**KIRKLEES METROPOLITAN COUNCIL
INVESTMENT & REGENERATION SERVICE**

Reference No: 2020/62/94189/W

Site Address: 16, Yew Green Avenue, Lockwood, Huddersfield, HD4 5EW

Description: Erection of single storey rear extension

Elevations as Proposed				
Date:	Scale:	Project No.	Dwg. No.	Rev.
May 2020	1:100 @ A3	082	04	A
Purpose of Issue: Planning

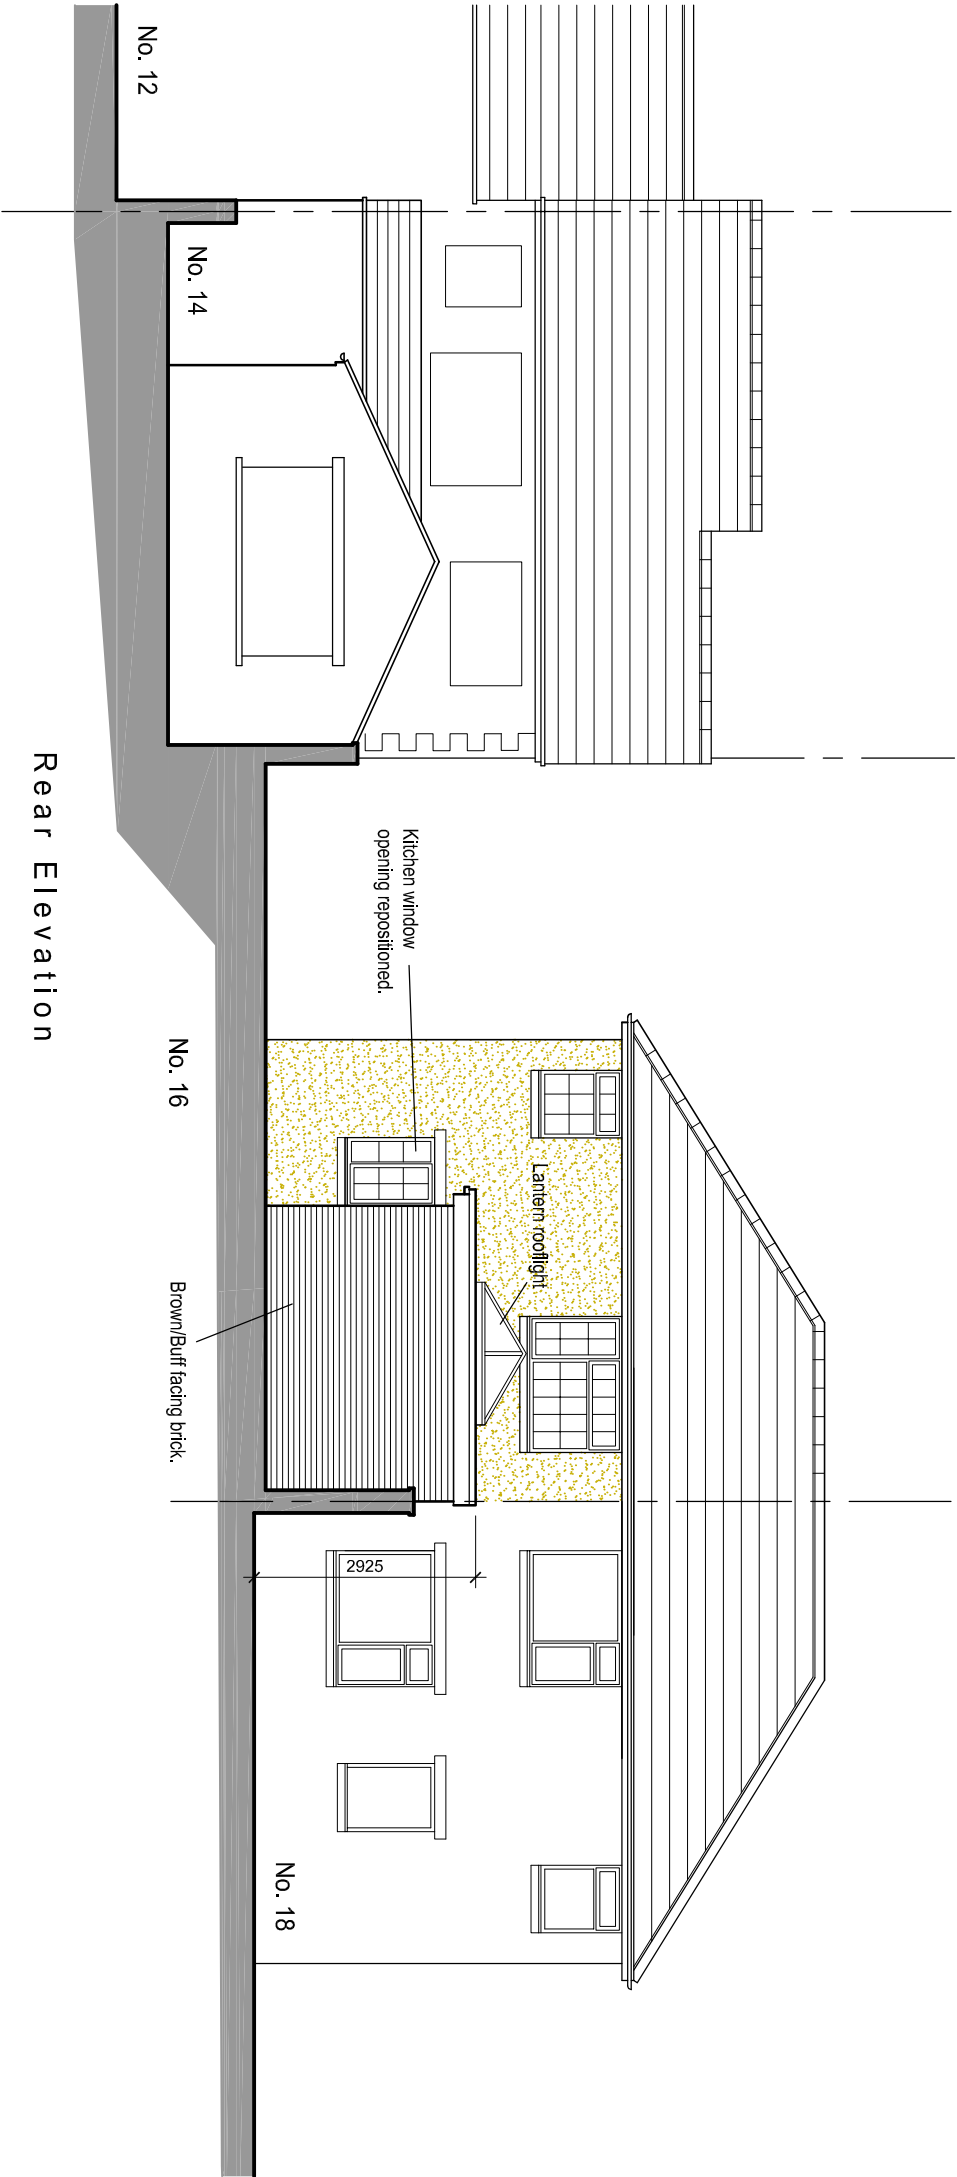
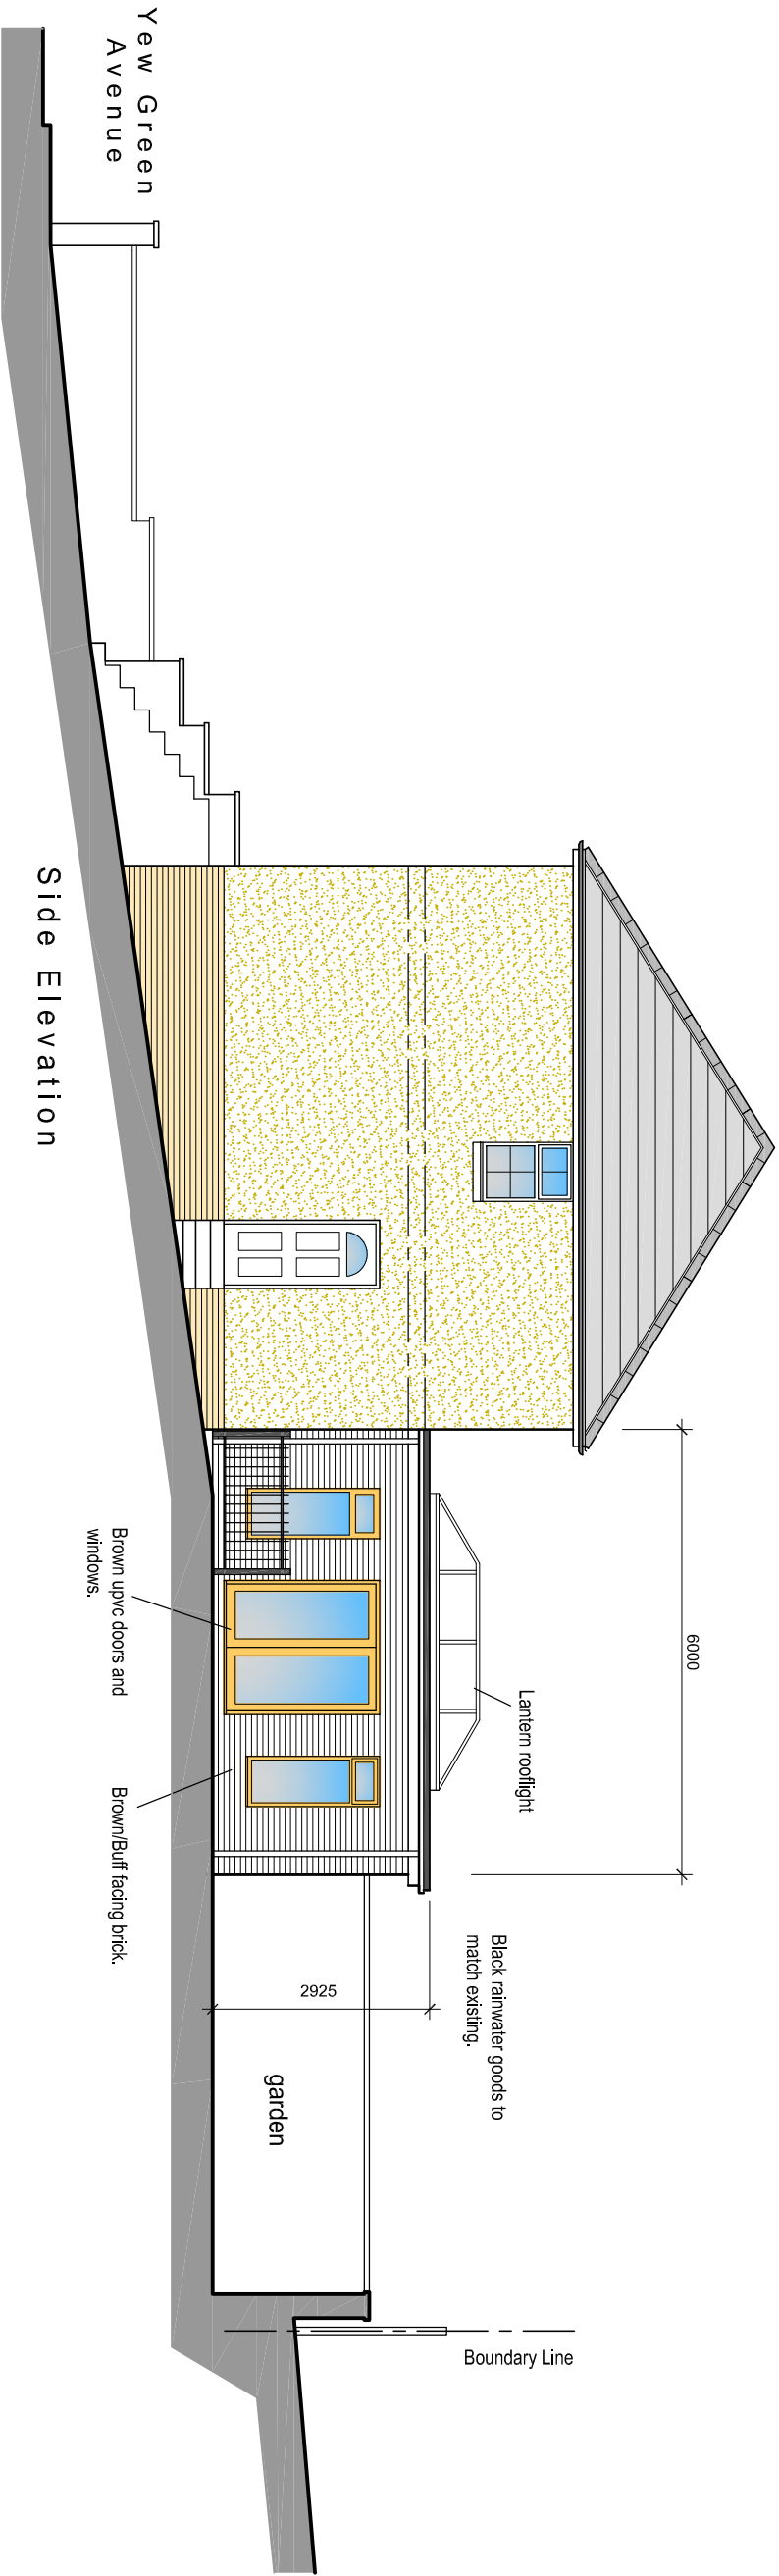
The case officer considered the application and requested the extension be faced in render to match the main cladding material of the host dwelling and the south side elevation in plans.

While it is noted that the extension is large it is to the rear of the property and would have minimal impact on the street scene. The plans indicate that the size of the extension would not be considered overdevelopment of the plot and that it would sit comfortably with the area’s character with similar rear extensions. The rear extension would be subservient to the host dwelling due to its single store nature with overall height and restricted width and the construction materials would match the host dwelling in pebble dashed render.

South Elevation as Proposed				
Date:	Scale:	Project No.	Dwg. No.	Rev.
May 2020	1:100 @ A3	082	05	-
Purpose of issue: Planning

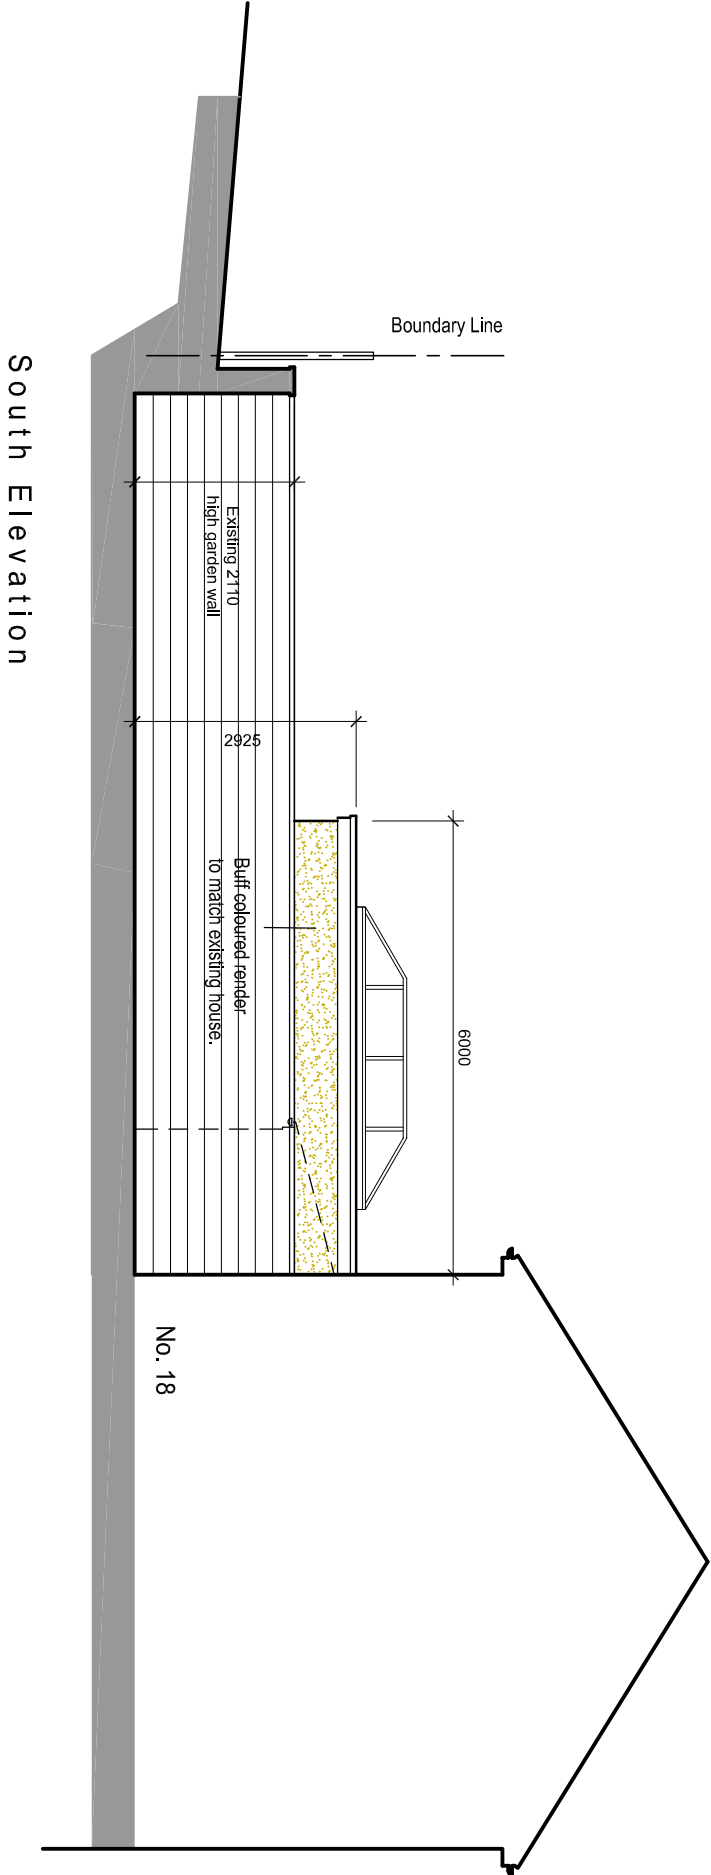
The neighbouring paired property to the south, No. 18 would be most affected by the extension due to its location adjacent the shared boundary. The proposed extension would not have windows facing its neighbour to the south and the submitted plans set out that the existing boundary treatment would be retained. Therefore the proposal would not lead to any detrimental overlooking to no.18.

Turning to overbearing it is noted that the submitted plans set out that the neighbour's ground level is lower than No. 16's and the extension would be 2925mm in height. The extension's height is 2700mm approximately from the host property. The extension would increase the height of the party wall by approximately 80mm for the neighbour which is on balance considered to be relatively modest. Whilst it is noted that the extension would sit against the party wall, it would have minimal extra height over the existing wall and have a flat roof reducing its profile as far as is practicable. It is therefore considered that the extension would not be detrimentally overbearing.
